**Rezoning Transportation Analysis**  
**Petition Number: Insert Zoning Petition #2021-063**  
*General Location Identifier: 14124101*

Revision Log:	Date	Description
	05-27-2021	First Review (KP)
	06-24-2021	Second Review (KP)

## SITE PLAN

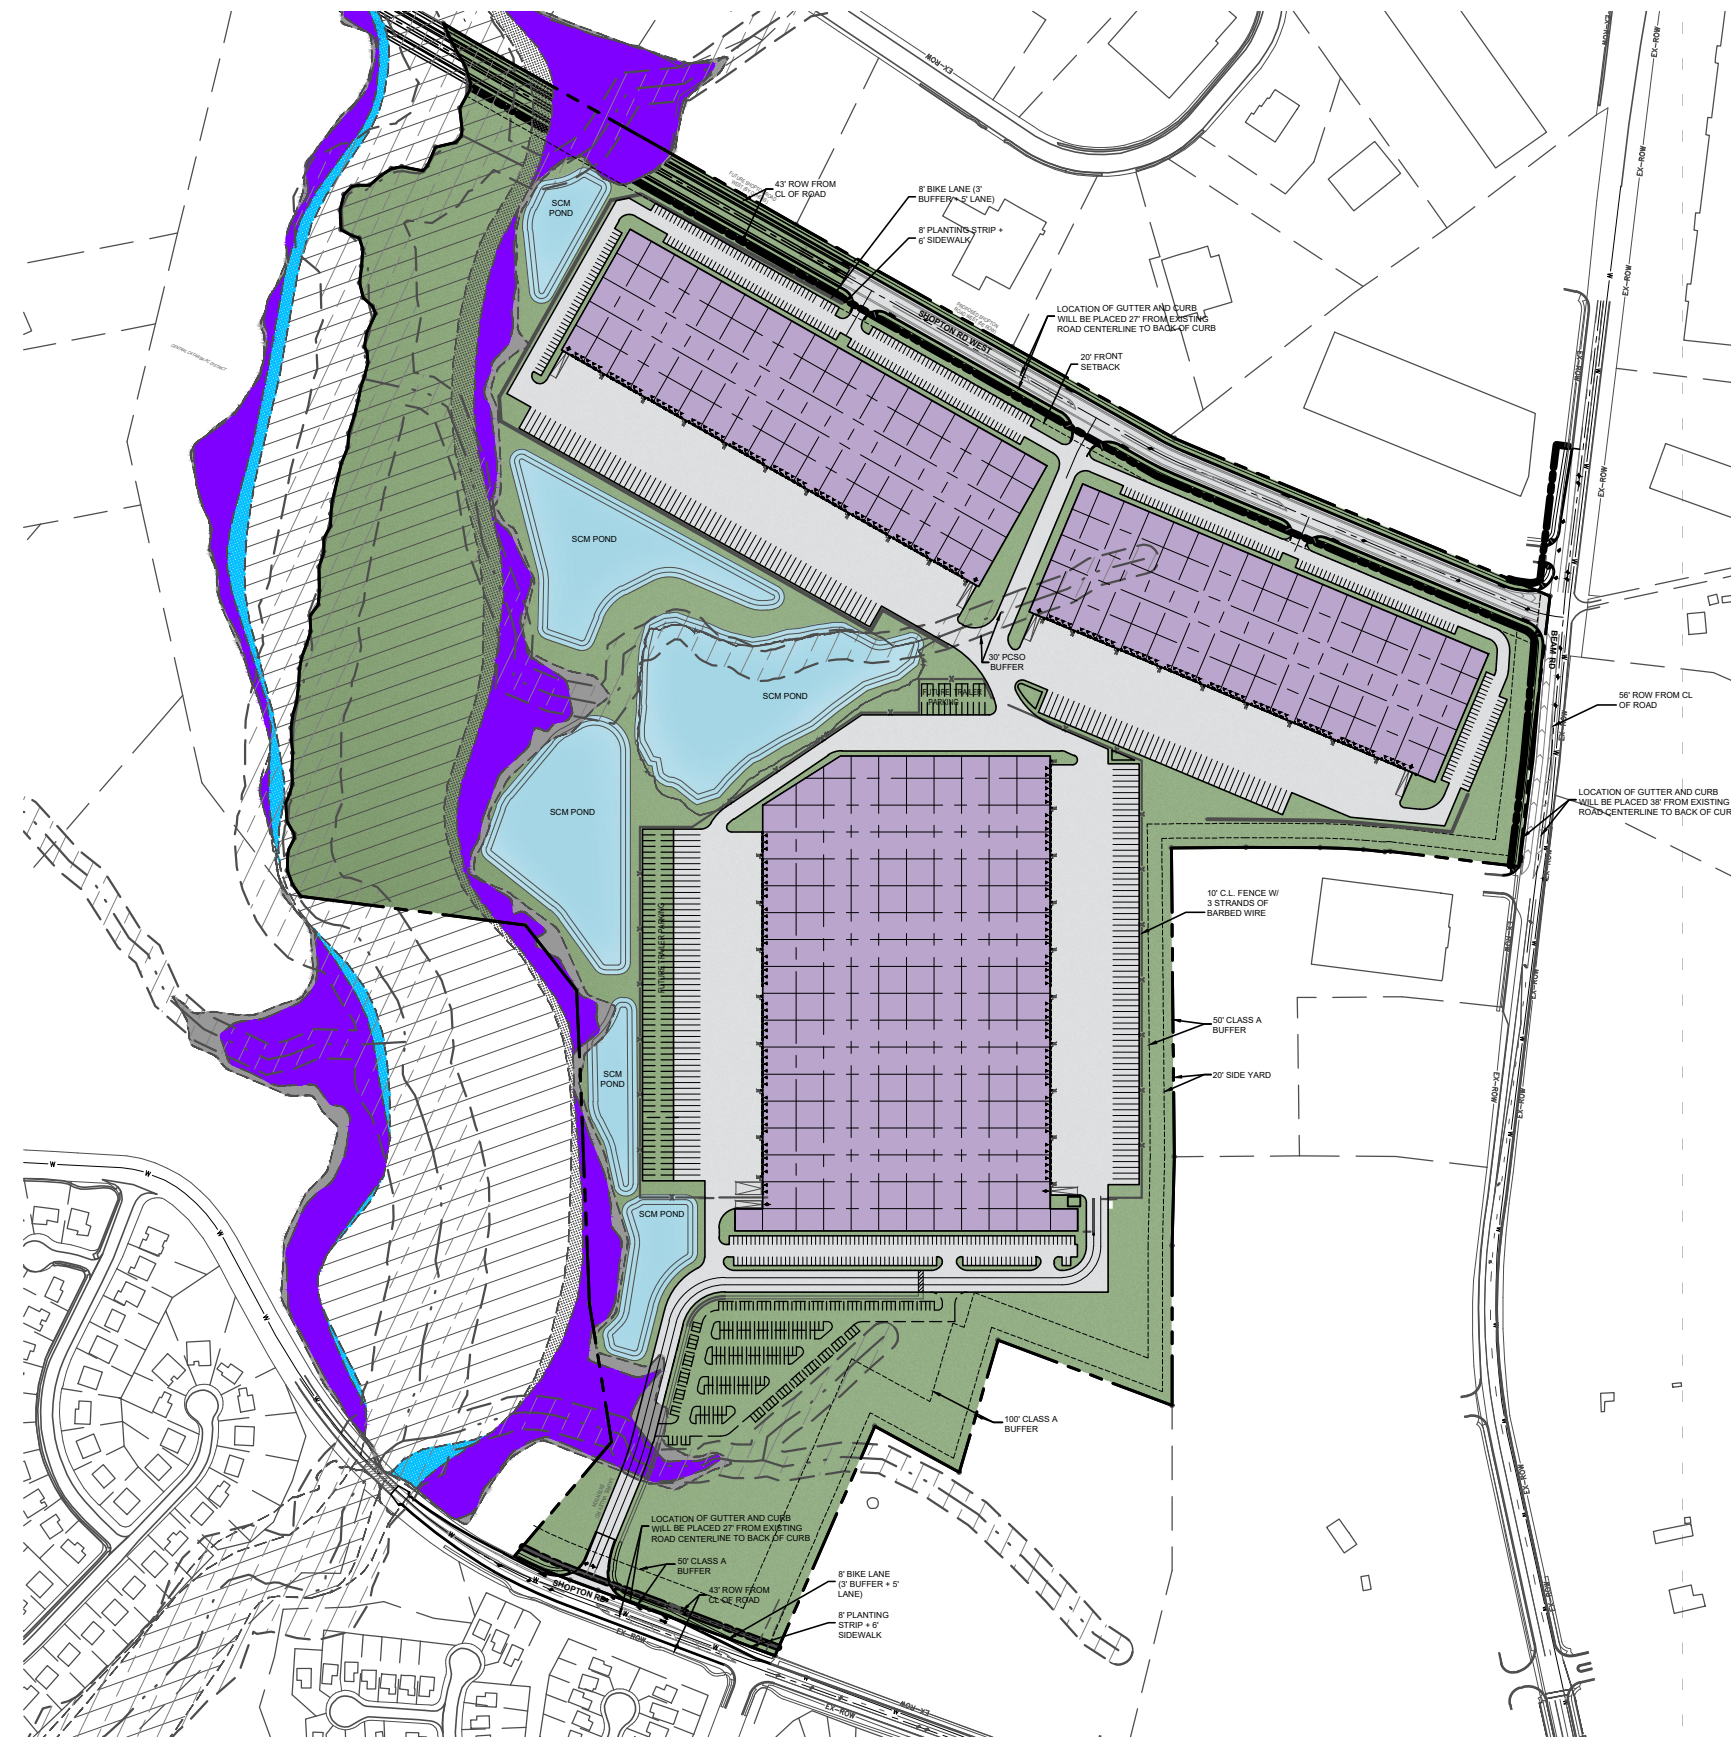
- 11. Revise the site plan and conditional notes by committing to dedicate the right-of-way for the future segment the Shopton Road Extension, that will not be constructed with this development, to CDOT. The amount of right-of-way dedication should be proportionate with the cross section established in Note 10 of this memo.

**Update to Comment as a Result of the 06-16-2021 Site Plan:** Label the total width associated with right-of-way dedication associated with the Shopton Road Extension.

**Update to Comment as a Result of the 06-16-2021 Site Plan: Revise conditional note III.i by modifying the phasing of the Beam Road transportation improvements. All the transportation improvements on Beam Road shall be completed prior to the Shopton Road Extension is connected to Beam Road.**

- g. The Petitioner shall indicate right-of-way along the Site's northern property boundary for the future extension of Shopton Road West, as generally depicted on the Rezoning Plan, to be further coordinated with CDOT during the permitting phase of development. The Petitioner shall construct a portion of the Shopton Road Extension CTP Alignment, as generally depicted on the site plan up to the Site's western access point and dedicate right-of-way to CDOT for the future alignment beyond the western access point.

- i. Phasing. All transportation improvements related to the northern portion of the Site shall be approved and constructed **on or before the issuance of the first building certificate of occupancy for either of the two northern buildings on the Site, whichever is first, as generally depicted on the Rezoning Plan.** Transportation improvements related to the southern portion of the Site shall be approved and constructed or bonded before the issuance of the building certificate of occupancy for the southern building, as generally depicted on the Rezoning Plan.

- iii. Asphalt
  - a. **Asphalt** on Beam Road shall be approved and constructed prior to the connection of the Shopton Road Extension to Beam Road
